RE: Richmond Valley Solar Farm - Response to DPHI RFI dated 28 May 2024

Umwelt was engaged by Richmond Valley Solar Farm & BESS Pty Ltd (Ark Energy) to prepare the Environmental Impact Statement (EIS - SSD-4102024) for the Richmond Valley Solar Farm (the Project). Following review of the EIS, the Department of Planning, Housing and Infrastructure (DPHI) have requested additional information.

**FIGURE 1.2**

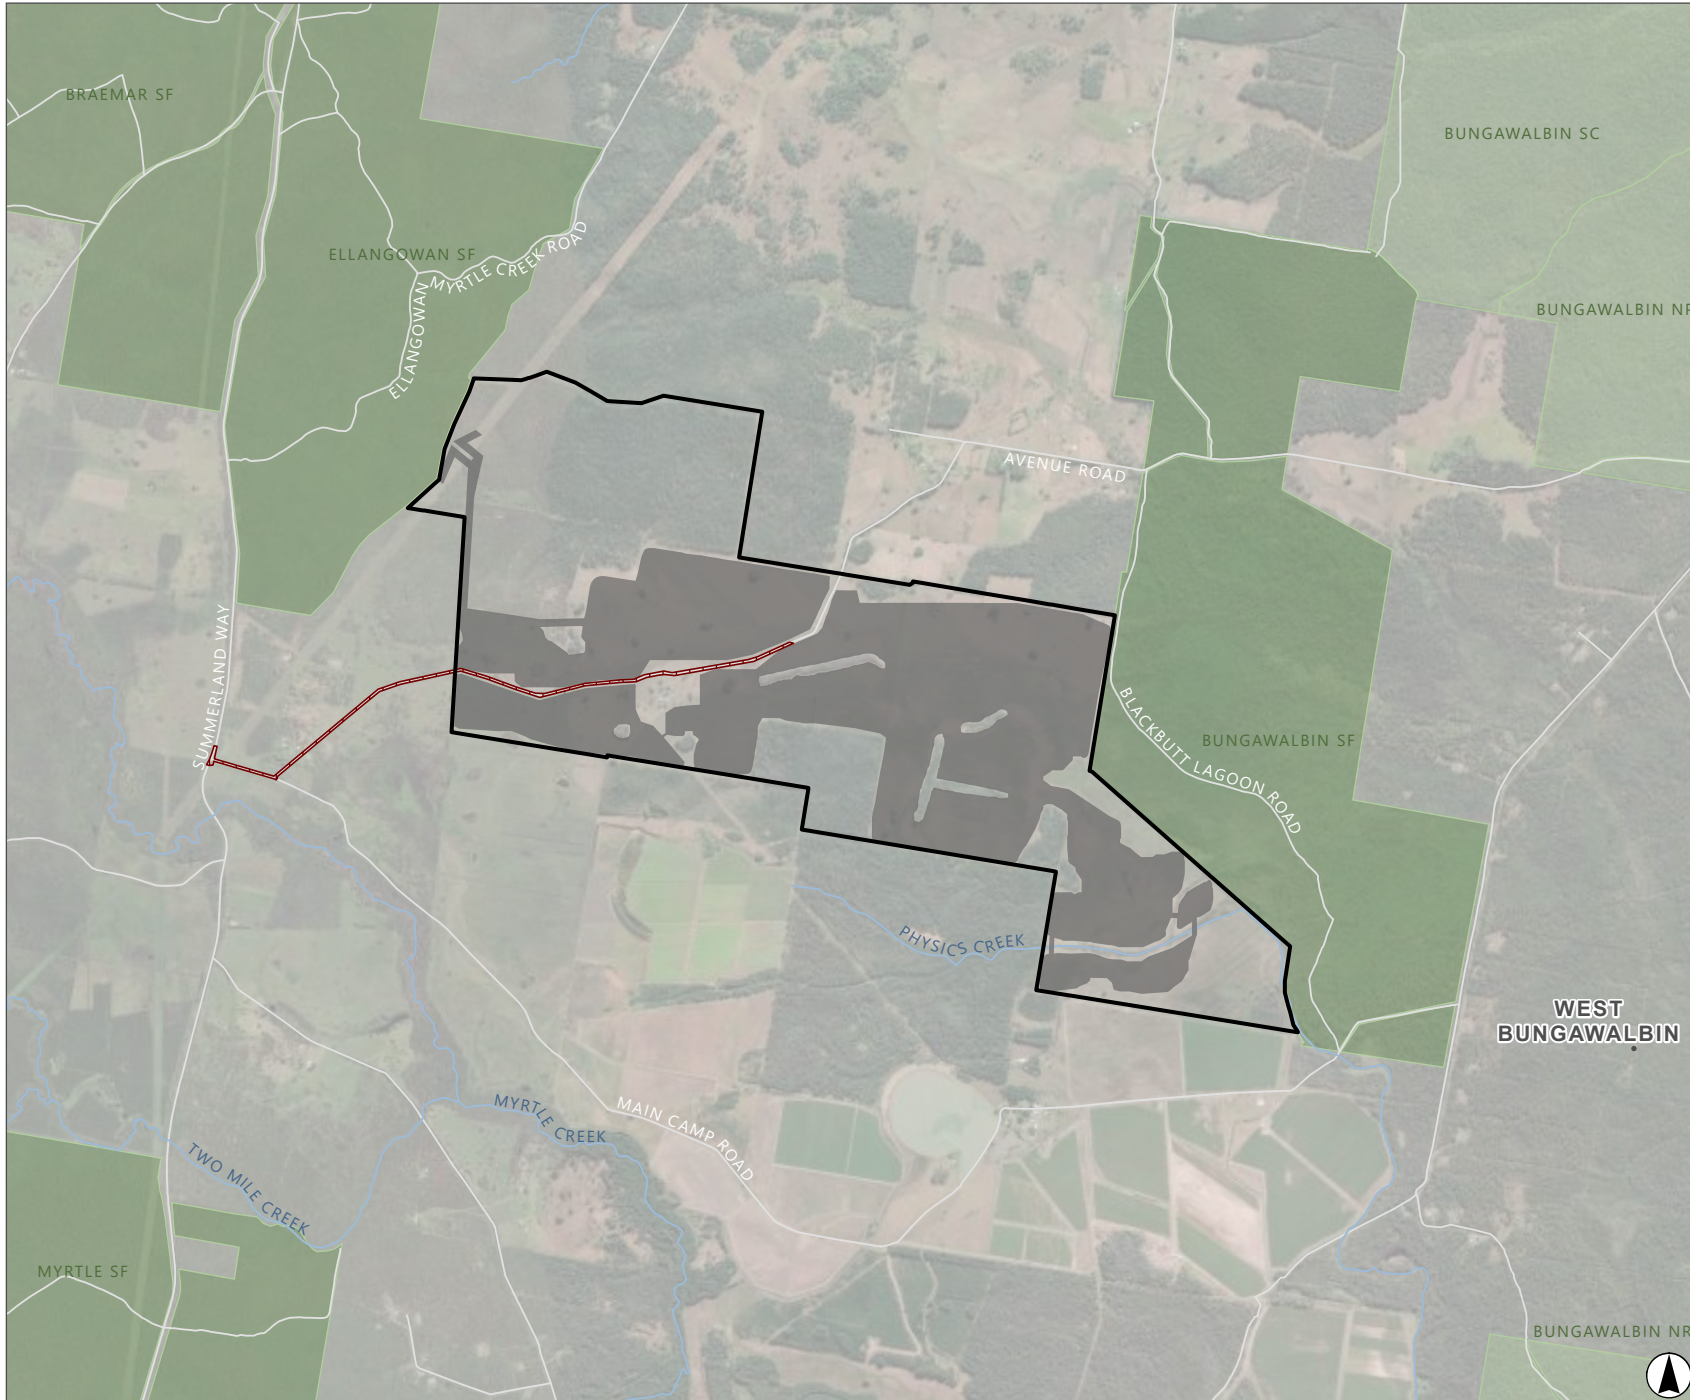
DPHI Request	Response
Provide an updated Project layout figure including key receivers, the biodiversity corridor and any watercourse crossings	<i>These details are currently provided in multiple figures within the EIS.</i> Additionally, Figure 1.2 of the EIS has been updated to include the details specified by DPHI including the location of water crossings, the biodiversity corridor and key receivers.
